**Ref: Planning Application R/90/18/HH
at no: 9 Park Drive, Rustington**

Further to the withdrawal of the applicant's earlier application, ref no: R/283/17/HH, and having inspected the details and plans of the applicant's revised proposals as shown on the Council's website I am writing to object to the above planning application for extensions to the existing buildings at no: 9 Park Drive, Rustington.

Drawing Number: 203 Rev C

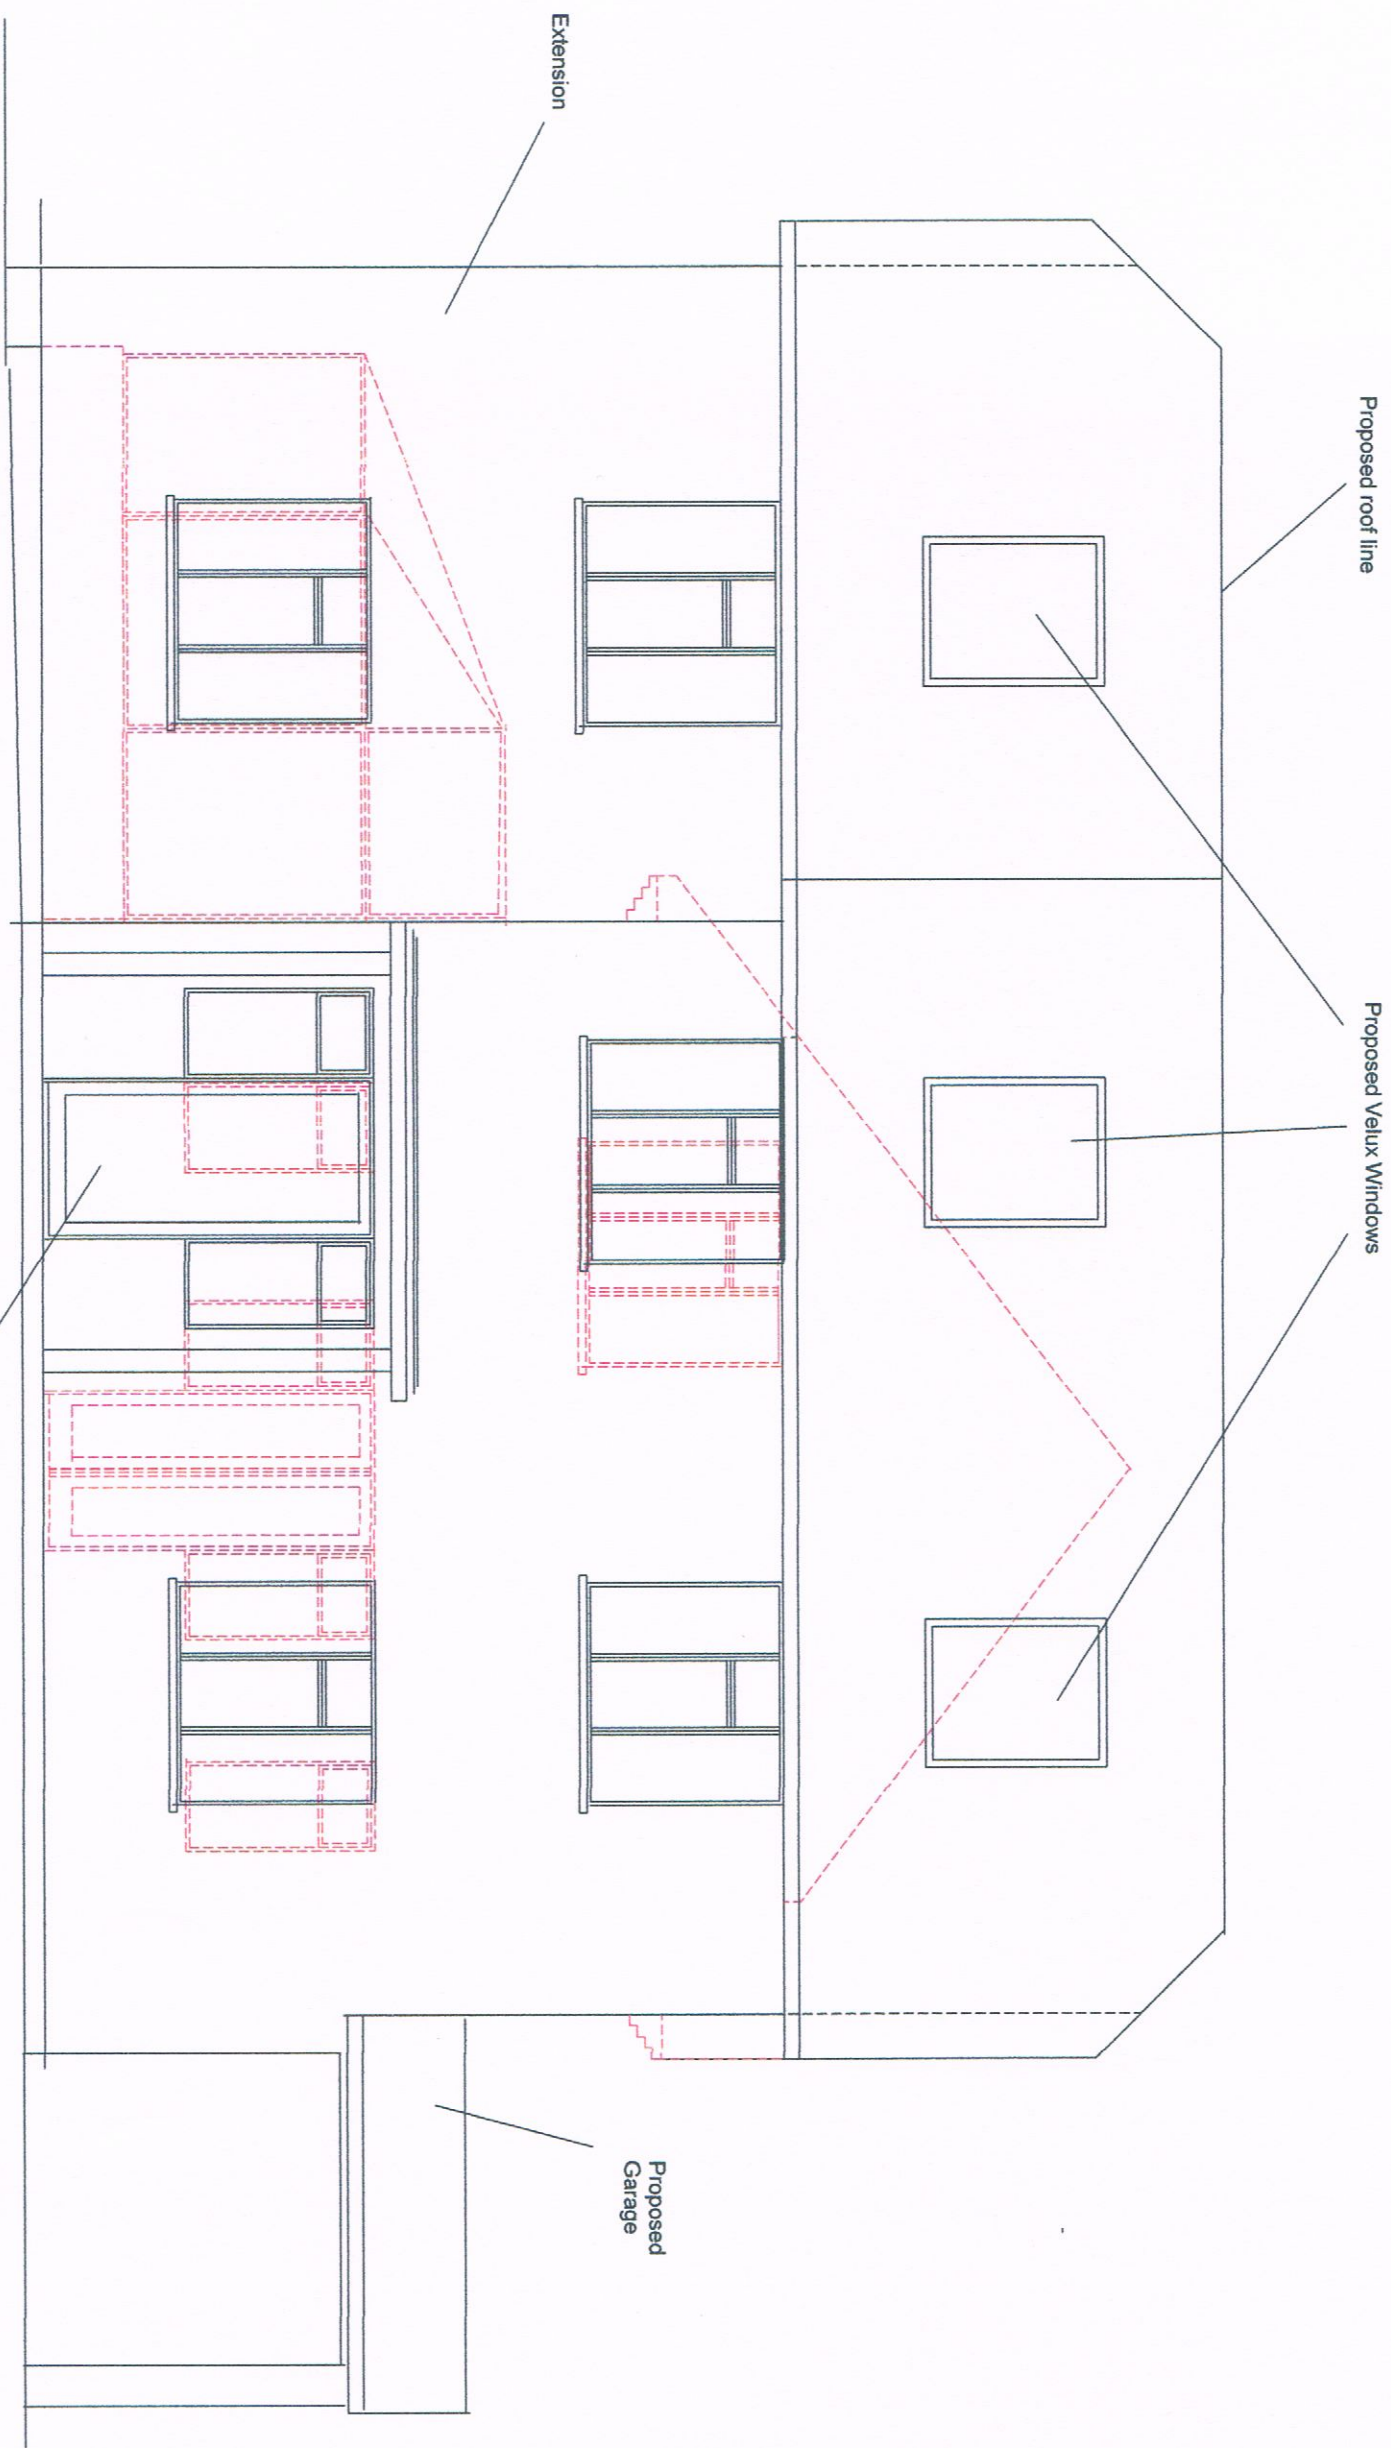
- (ii) Visual subservience to the existing building – the front ie east elevation of the proposed house shows that the proposed building has an area of some 49% more than the existing building. Such a major enlargement cannot be said to be subservient to the existing building.
- (iii) Overbearing effect and appearance – the extra height of the roof and the greater area of the roof over the longer re-orientated roofline axis will present the appearance of a significantly larger frontage and house than the existing from the street, Park Drive. The extra height, even with a small hip, will similarly affect those looking at the extended house from their flats on the northern side of Herne Court.

The sheer scale of the development would be overbearing and its eastern elevation would be intrusive to the neighbours especially those on the opposite side of Park Drive, in Herne Court and in St Anthony's Way.

Proposed Roof Plan

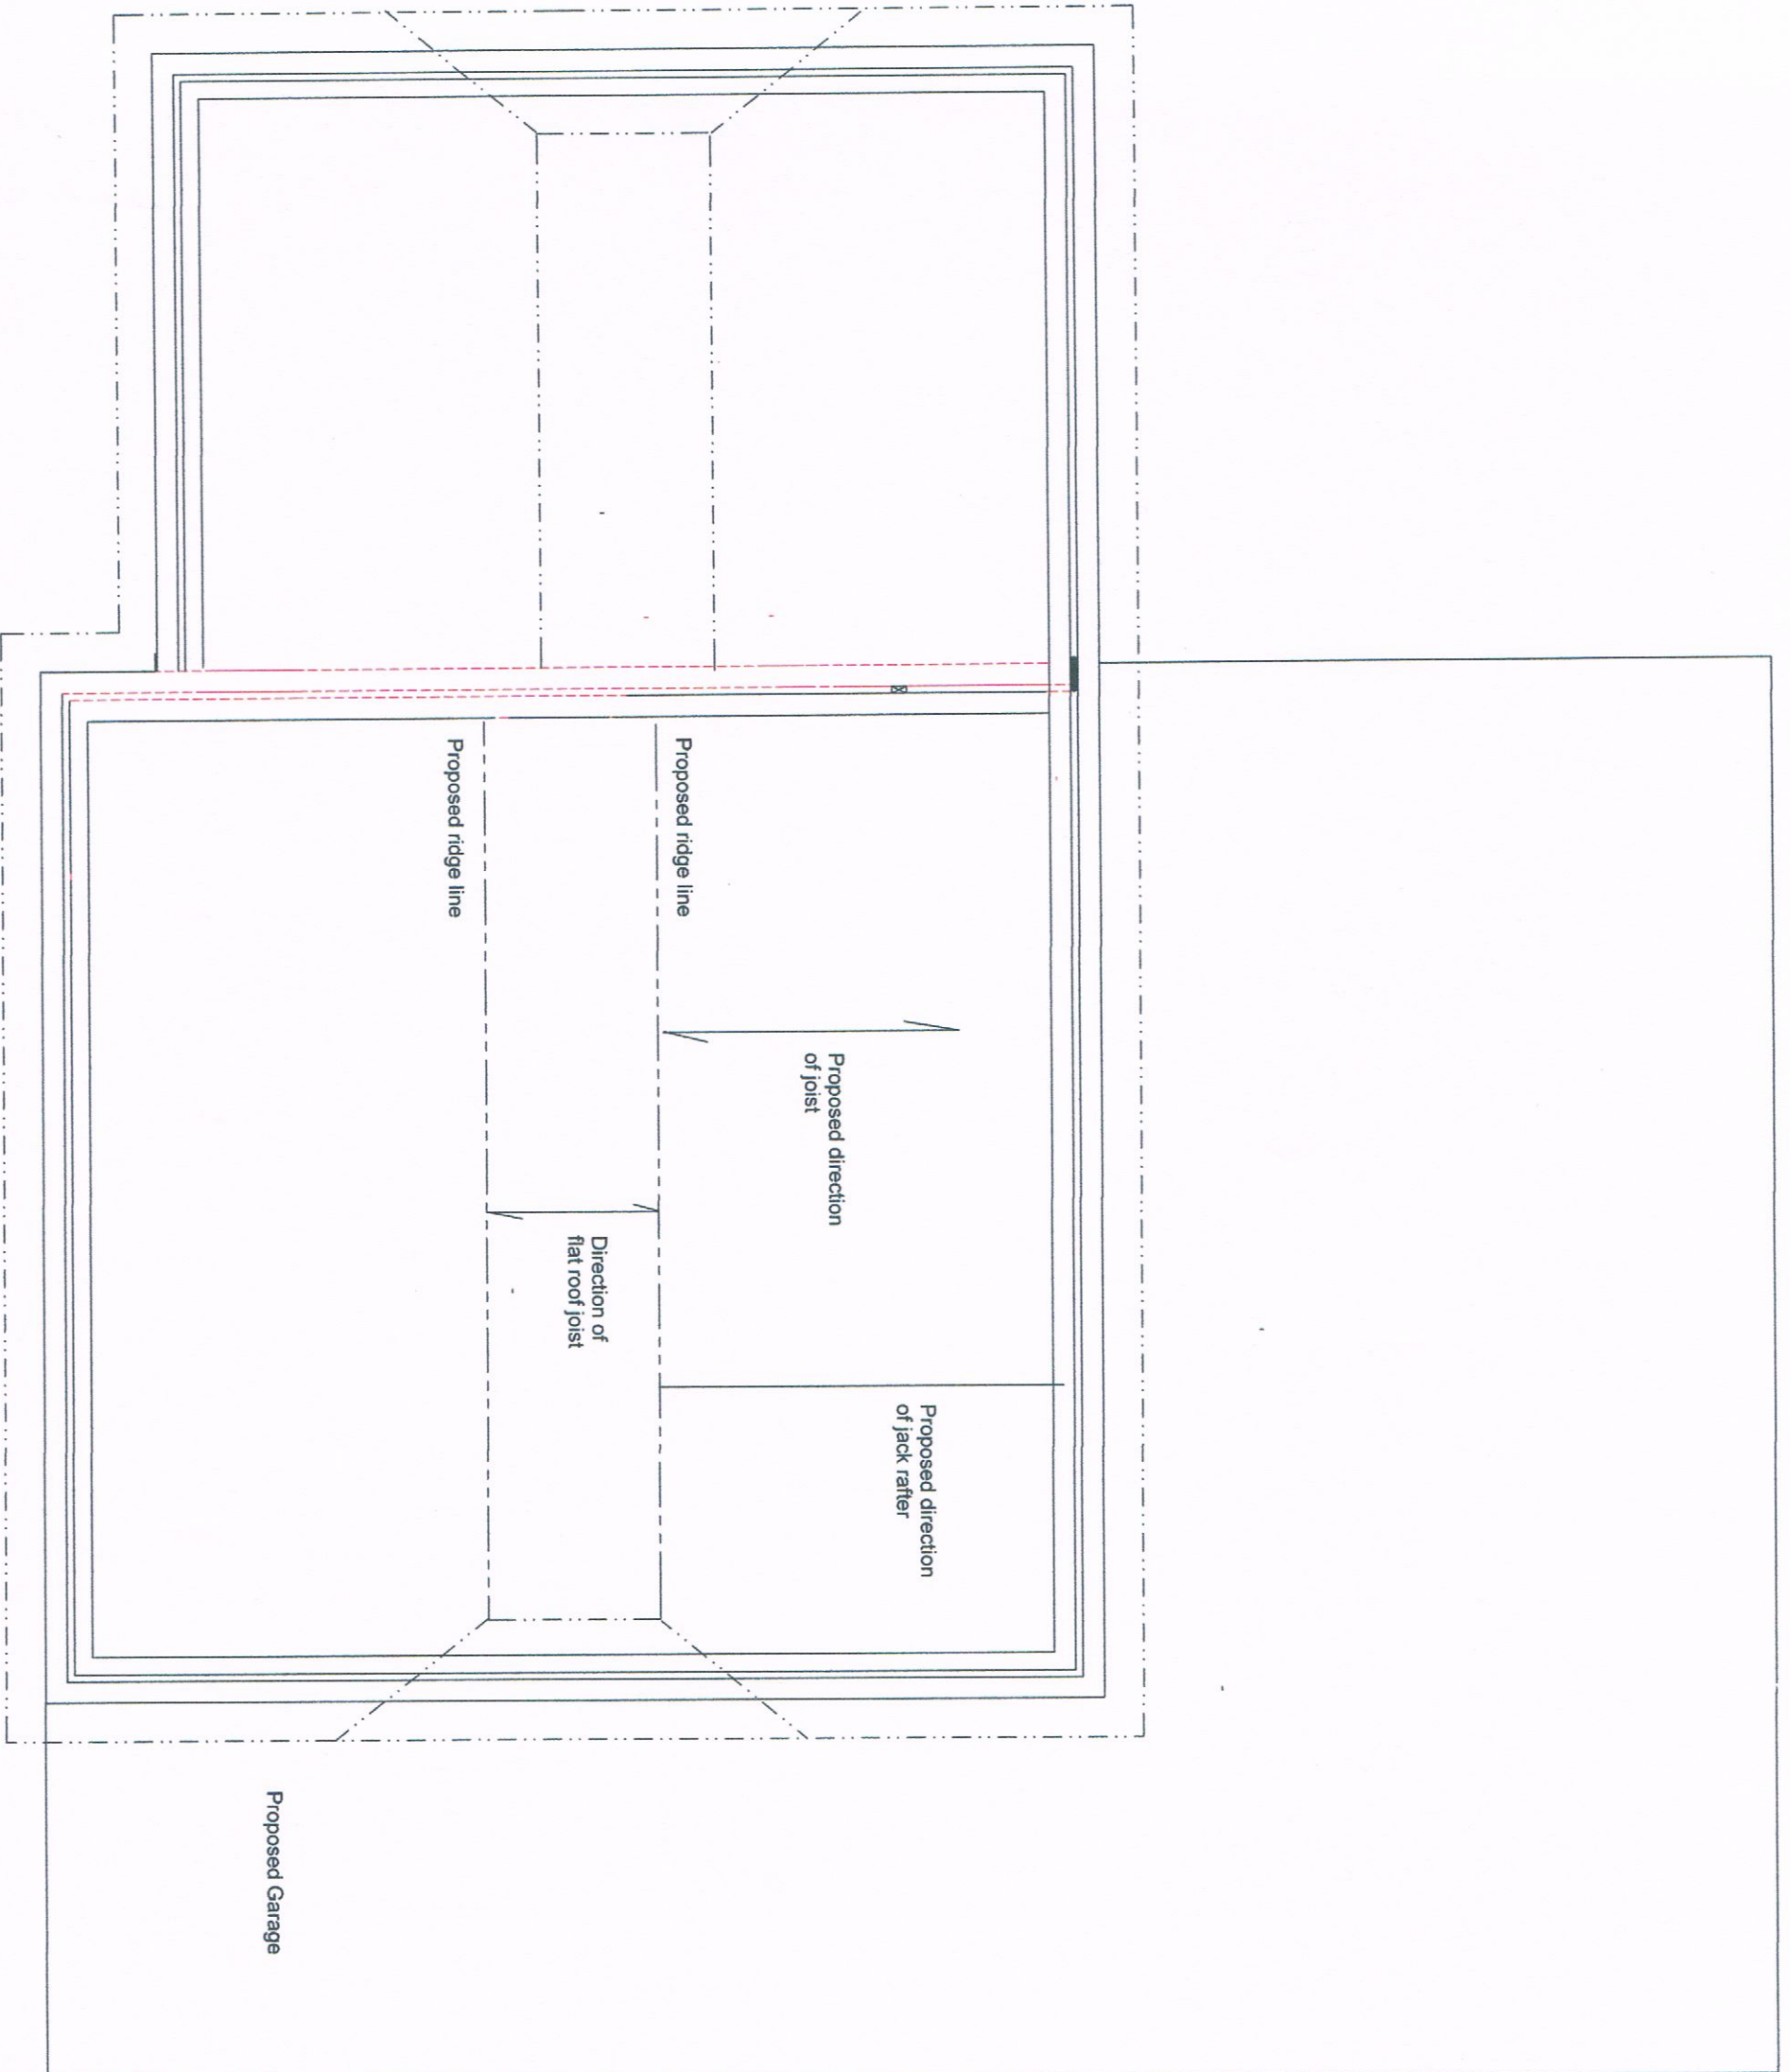
- (i) Integration with the existing building – the proposed extension would increase the roof height of the existing building by some 0.5 metres and as this higher roofline runs for 53% further than the existing this additional height has an even greater significance and the proposal does not relate sympathetically to nor is it visually integrated with the existing building.

The rotation of the principal axis of the house through 90° changes its axis from E-W to N-S and this does relate not sympathetically to, nor does it visually integrate with, the existing building.

- (iv) Relation to established spatial character and pattern – the three windows in the roof at both the front and rear of the proposed extension creates the appearance of the only three storey house in the road. The extension would also have such a wide frontage of roof slope as to be more like a small office block than a house and wholly out of character with the rest of the properties in this part of Park Drive. The mass of the enlarged building would amount to an over development of the site.
